CONSTRUCTION PLANS for JACKSON RANCH FILING NO. 4

JACKSON RANCH
FILING NO. 4
COVER SHEET

JACKSON RANCH COURT
FROM STA 16+75.71
TO STA 25+11.85
JACKSON RANCH FILING NO. 4

Markup Summary

JACKSON RANCH COURT

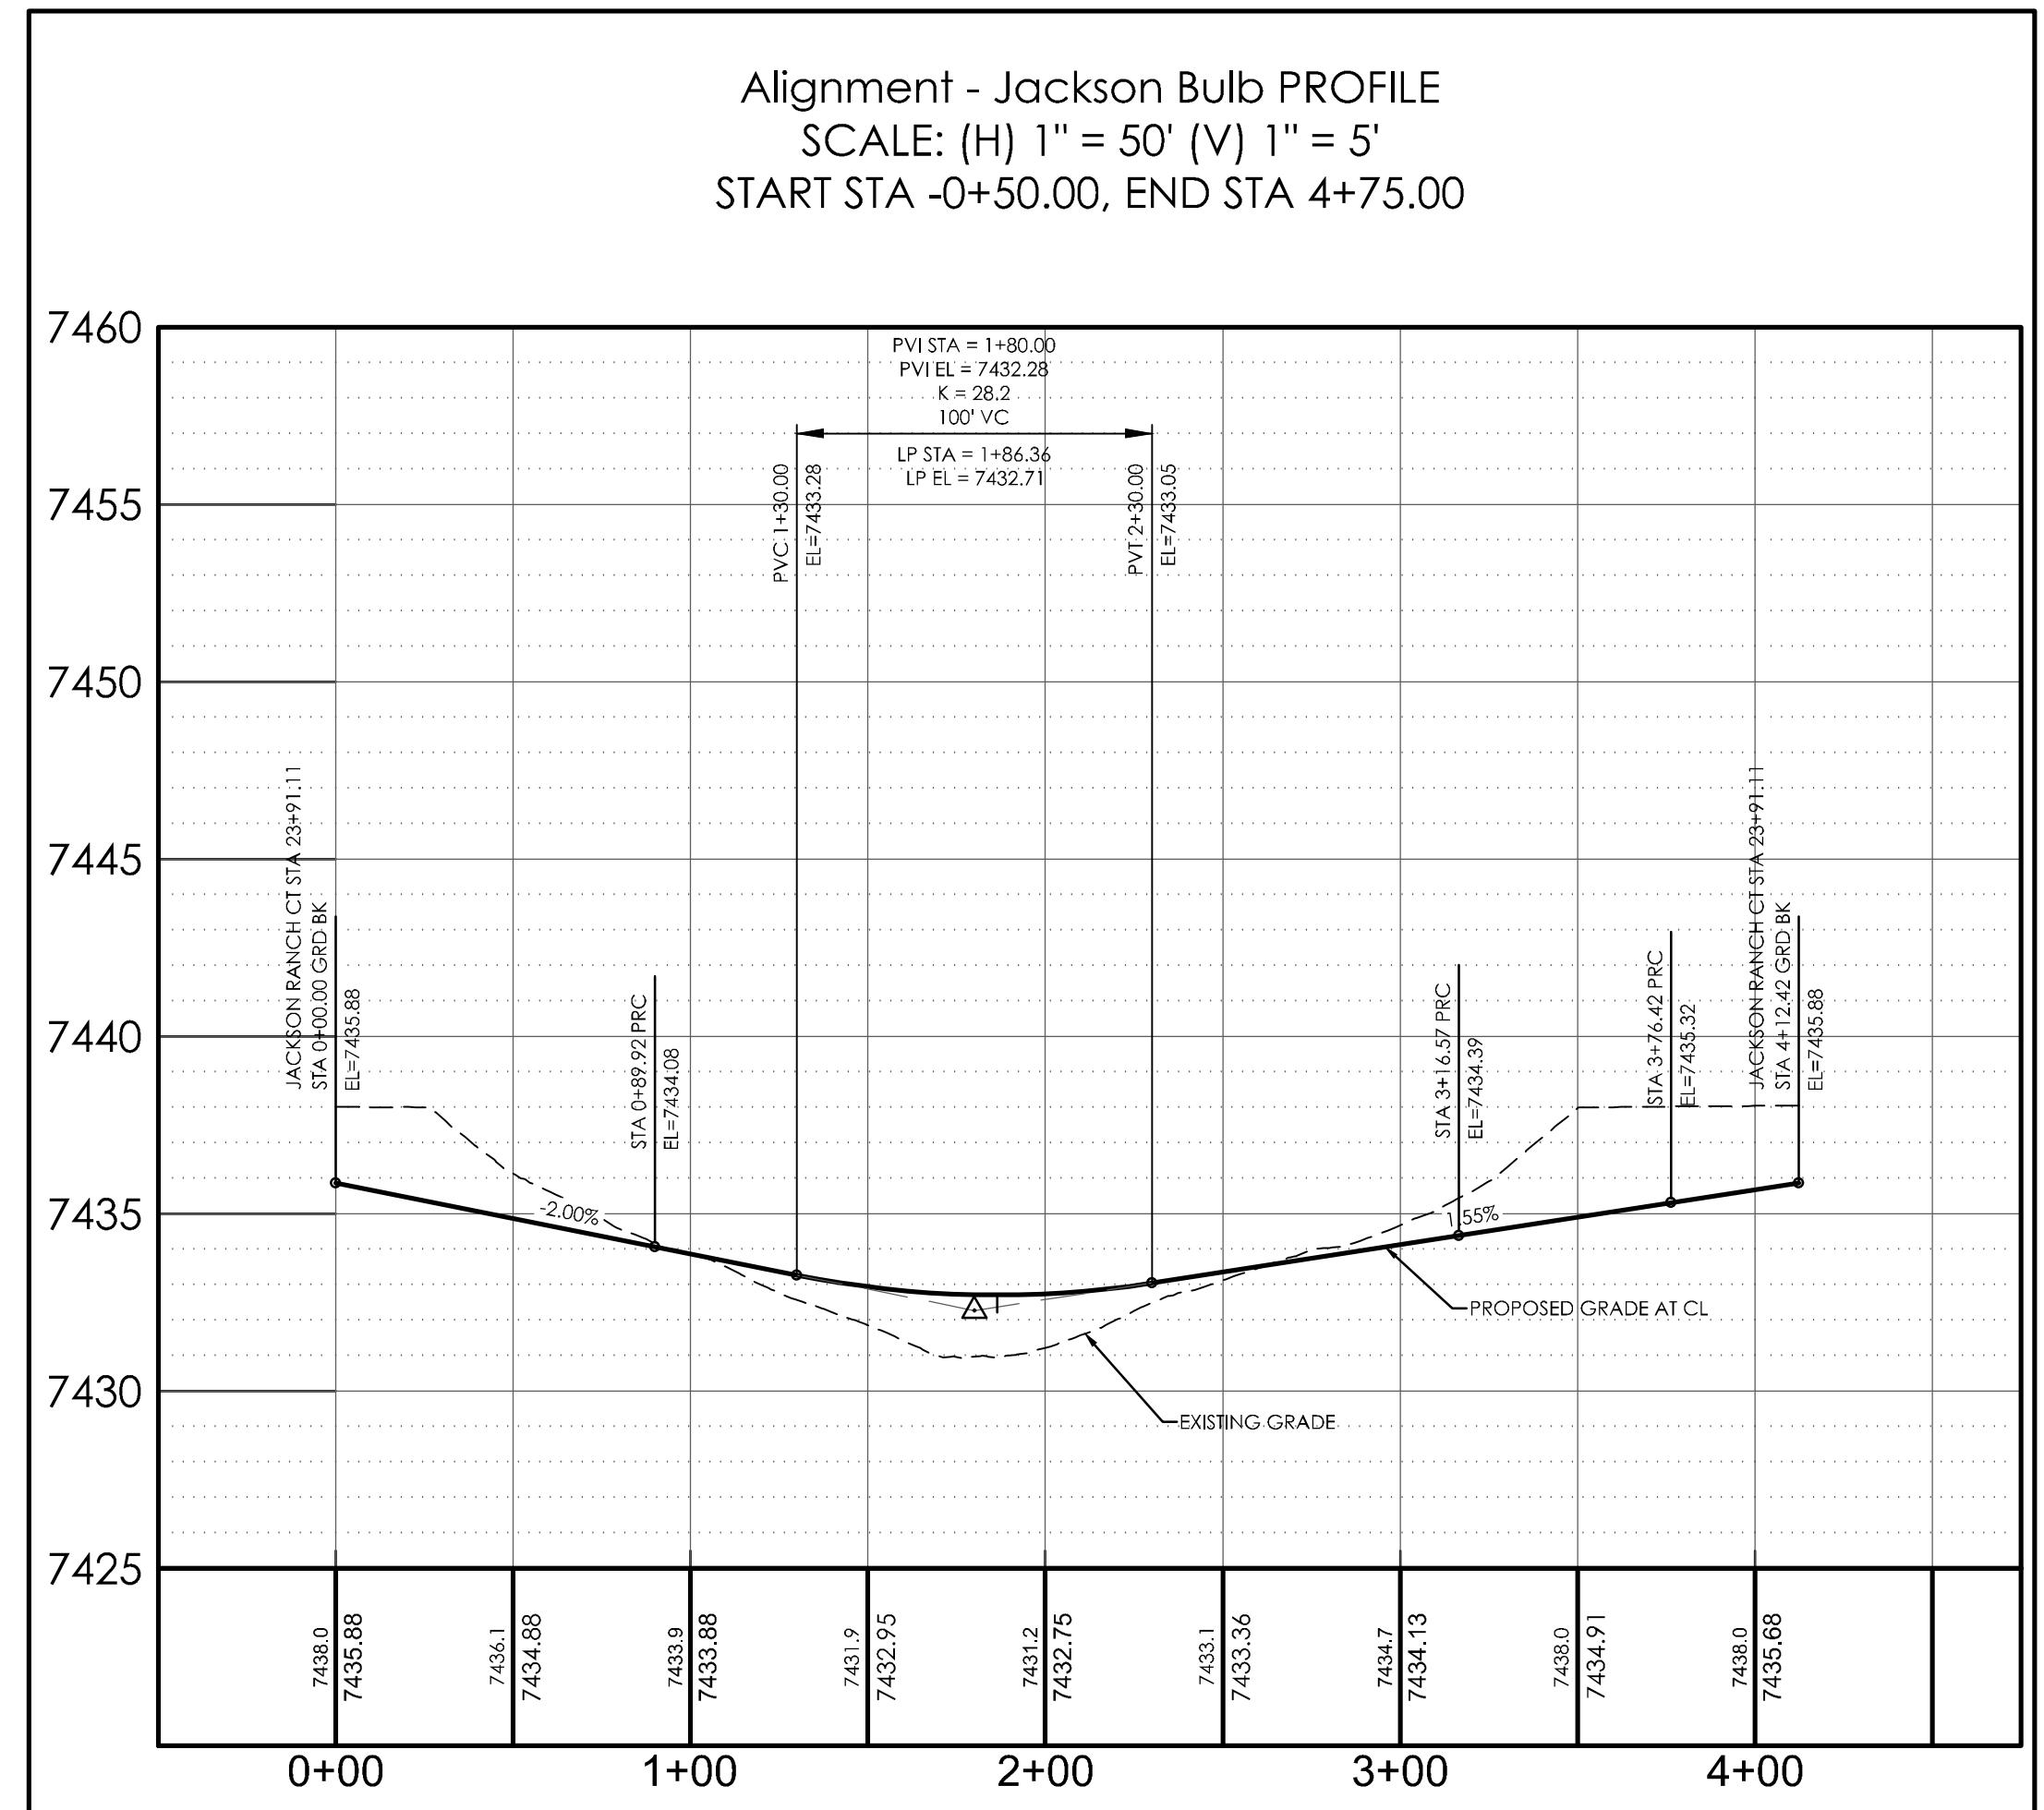
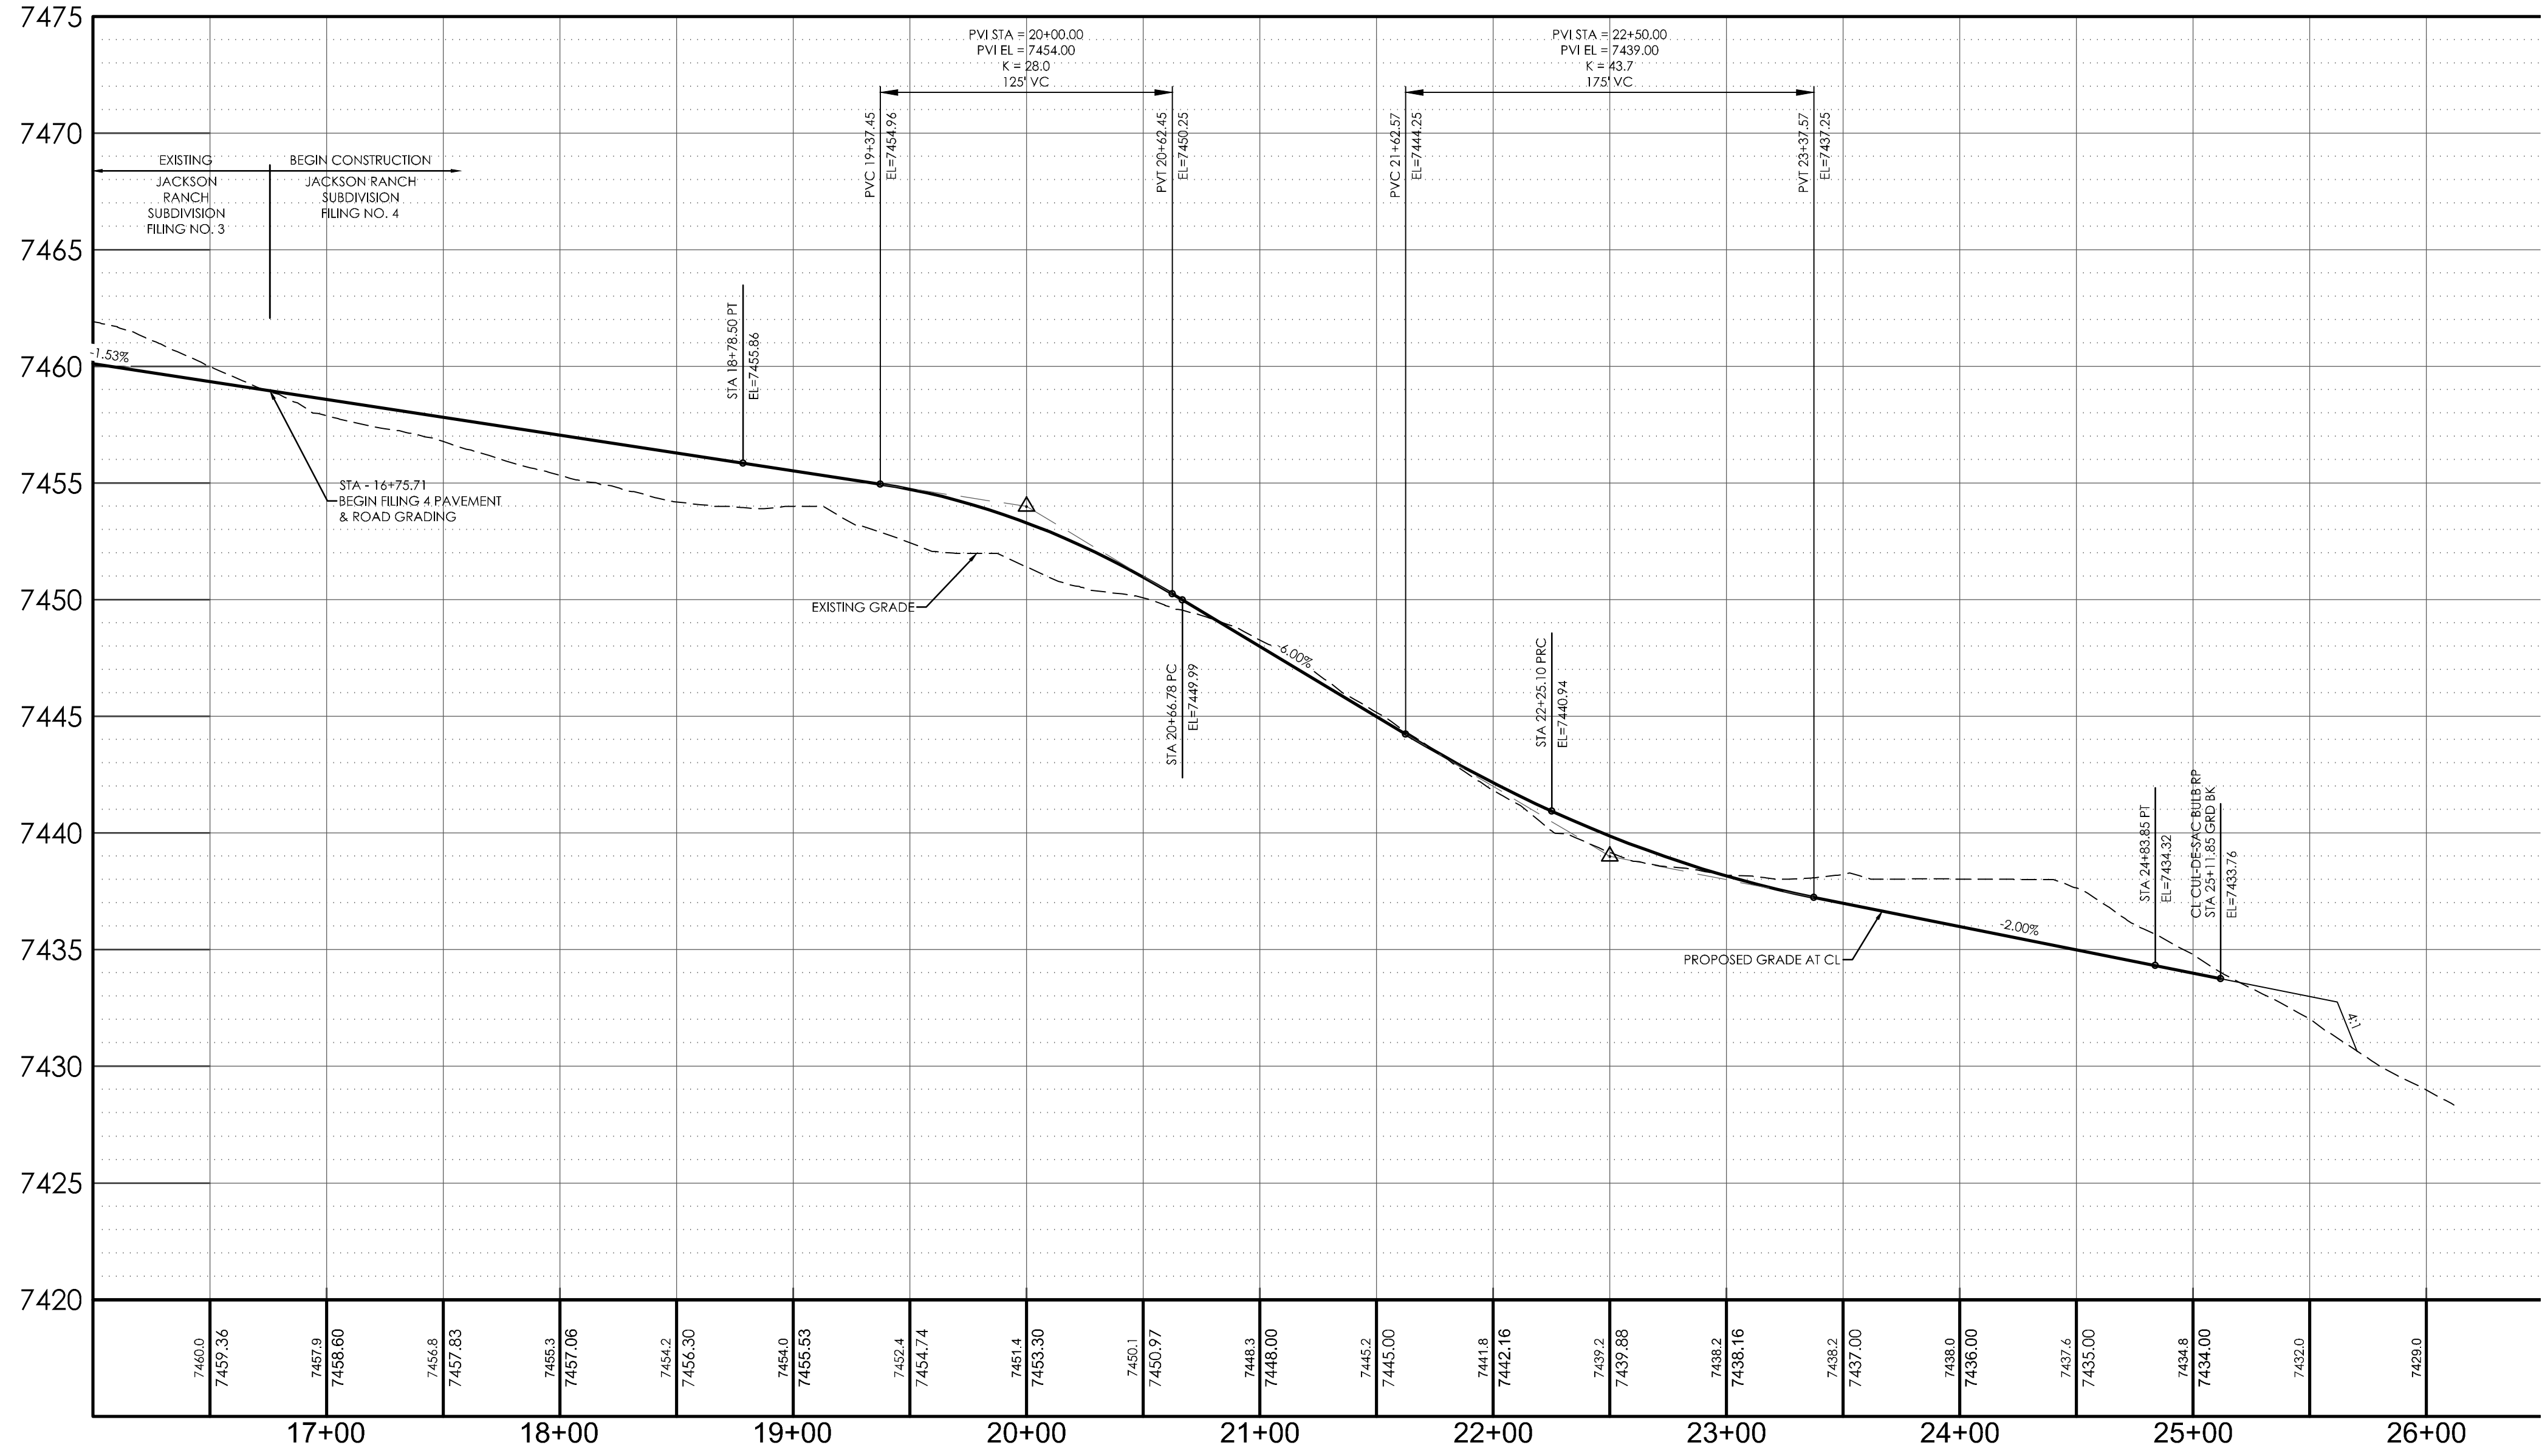
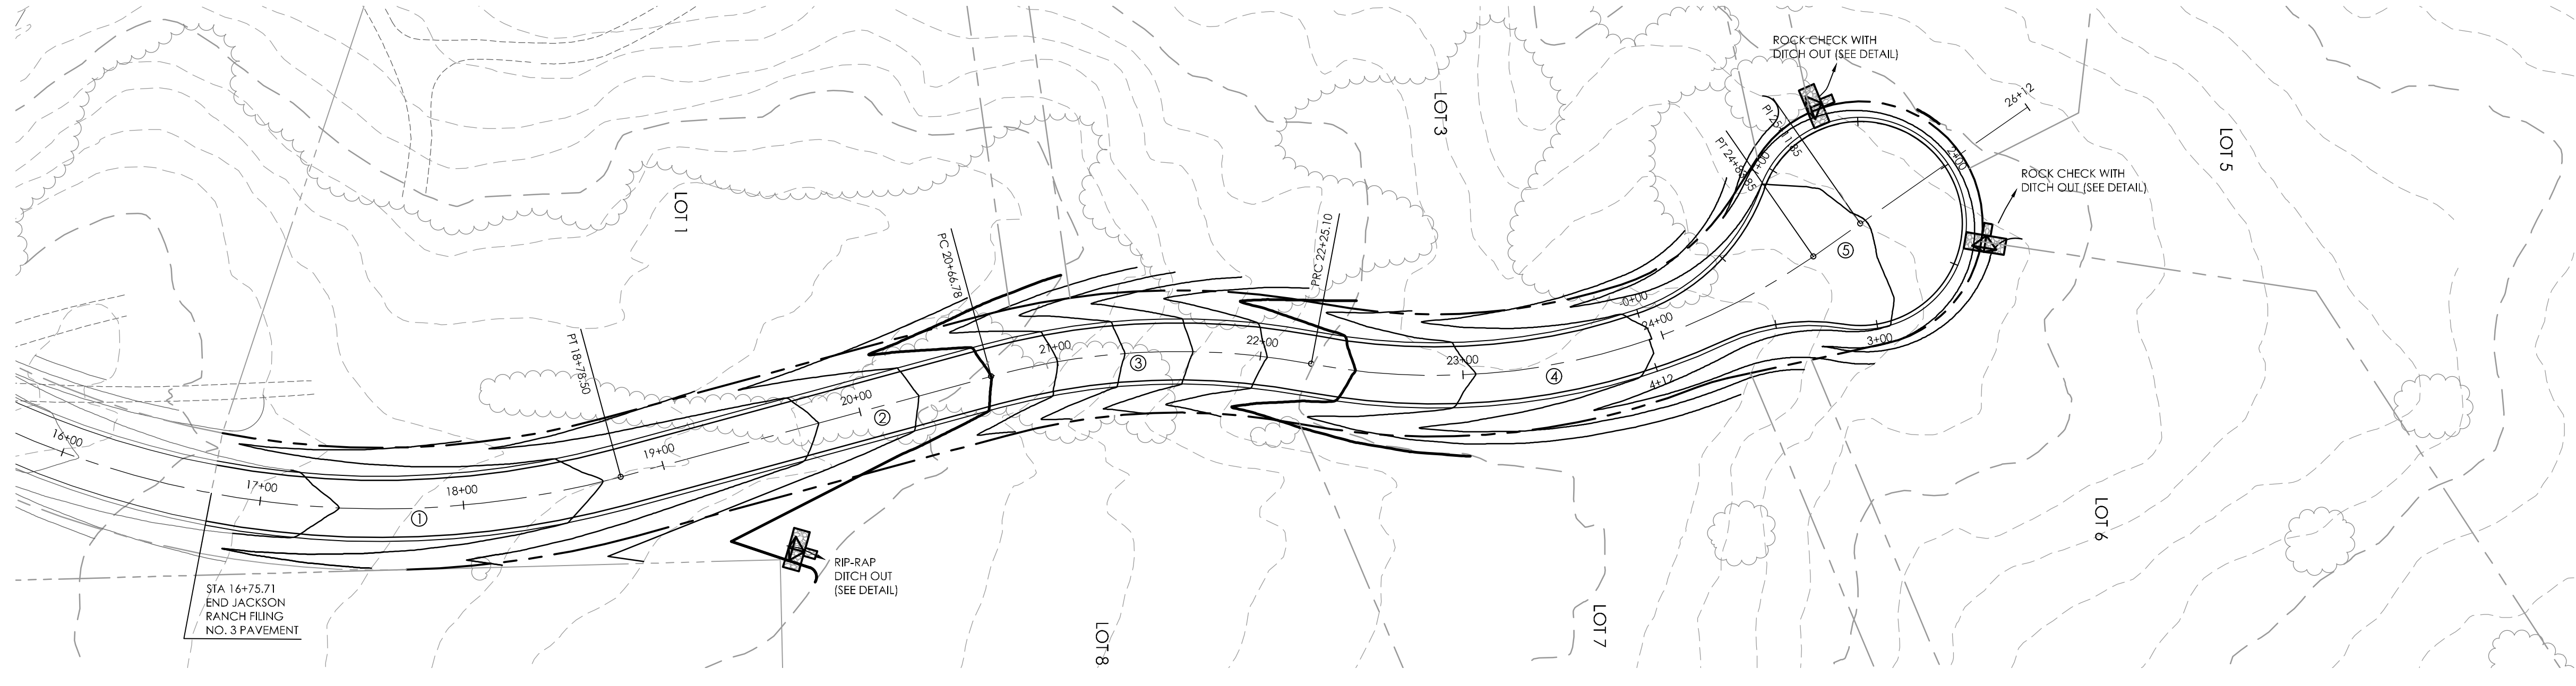
Hatch and callout the sections of the ditch that requires erosion control blanket.

Show the cul-de-sac bulb stationing and provide the station equation for where the centerline stationing ties into the bulb stationing.

The ditch should be carried through to the low point of the bulb. Also, the rock check is unlikely to change the concentrated flow to sheet flow. Erosion is likely to occur downstream of the rock check. Provide suitable erosion control protection.

Revise the ROW to print darker.
